Consultation Response from KC, Conservation and Design
2020/92307 Penistone Road/, Rowley Lane, Fenay Bridge, Huddersfield, HD8 0JS
Outline application for erection of residential development
Date Responded: 14/12/20
Responding Officer: Craig McHugh
Responding Ref: KB5/142
Summary

**Figure 8: Viewsheds from the pavement adjacent to 1 Woodsome Road**

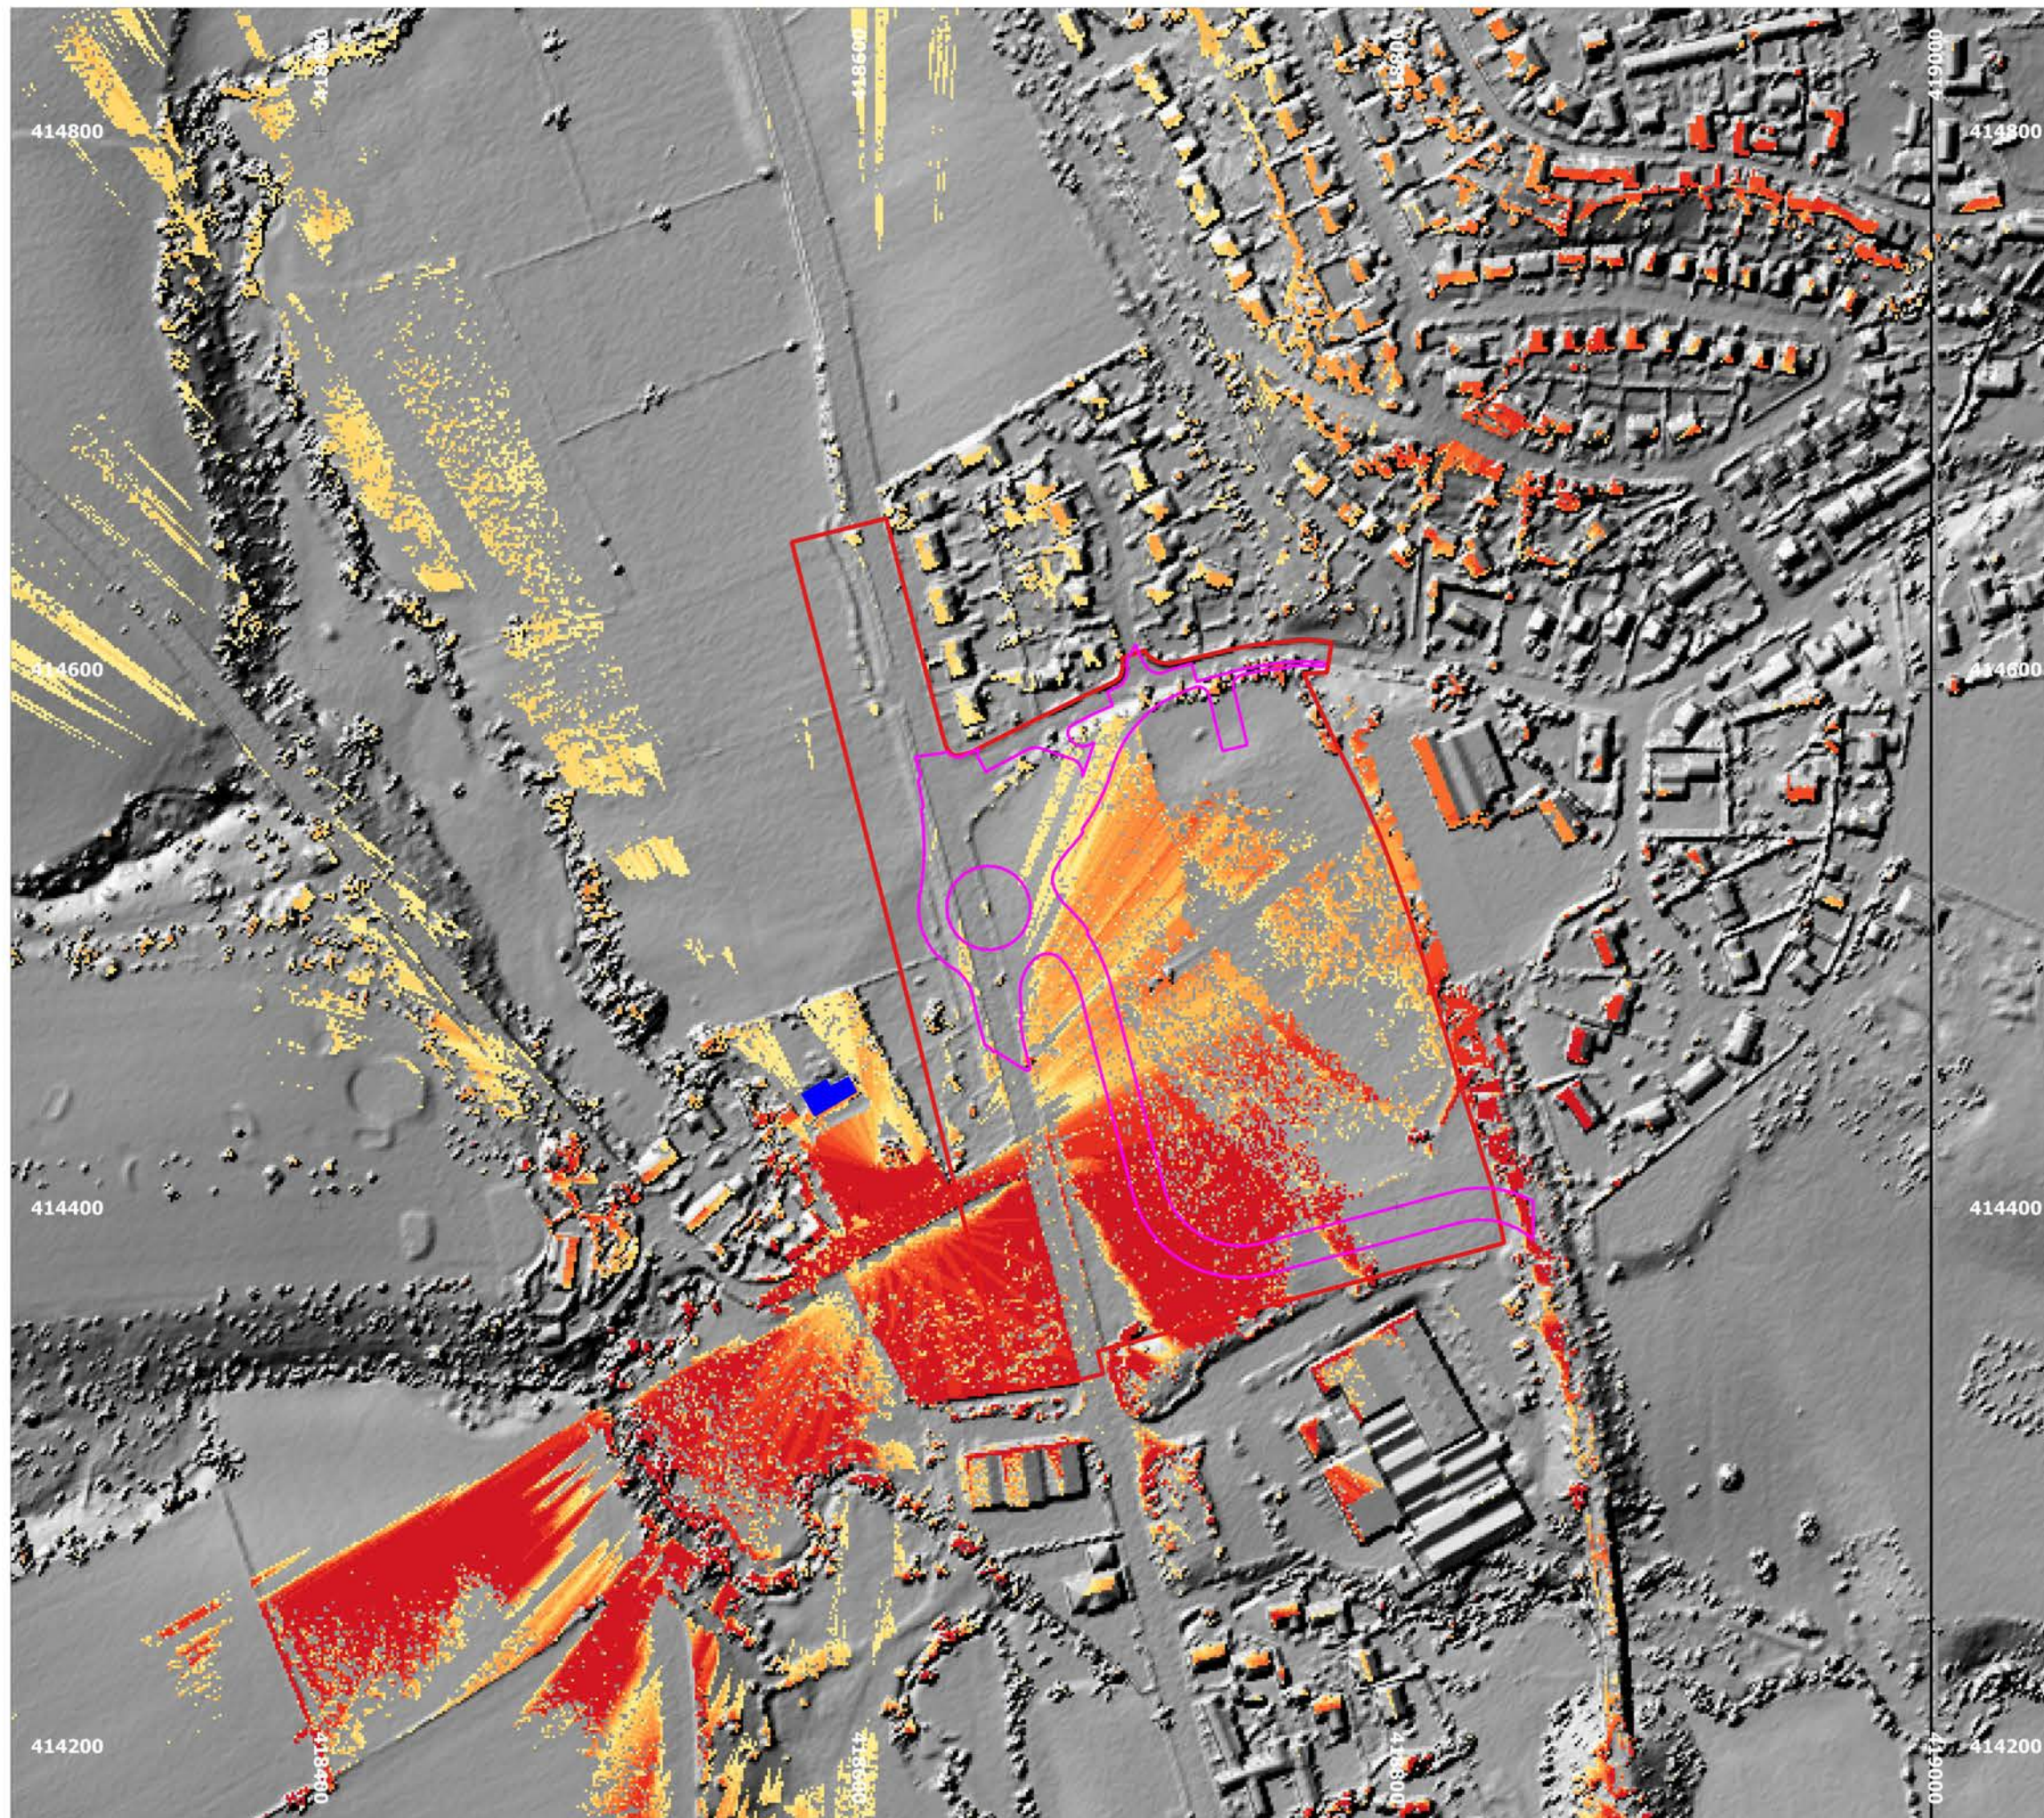
It is evident that the indicated roundabout would cause harm to the setting of 1 Woodsome Road due to the intrusion of the roundabout and associated lighting and traffic into a parcel of land that *contributes to* its setting. Visual impact assessment is also needed to evaluate the extent of the adverse impact and plan for the necessary mitigation for this designated heritage asset.

The submitted Heritage Statement only considers the impacts on Woodsome Hall, it does not consider impacts on 1 Woodsome Road, which is clearly affected by the roundabout proposal and the development of HS2. Visual impact assessments are also needed.
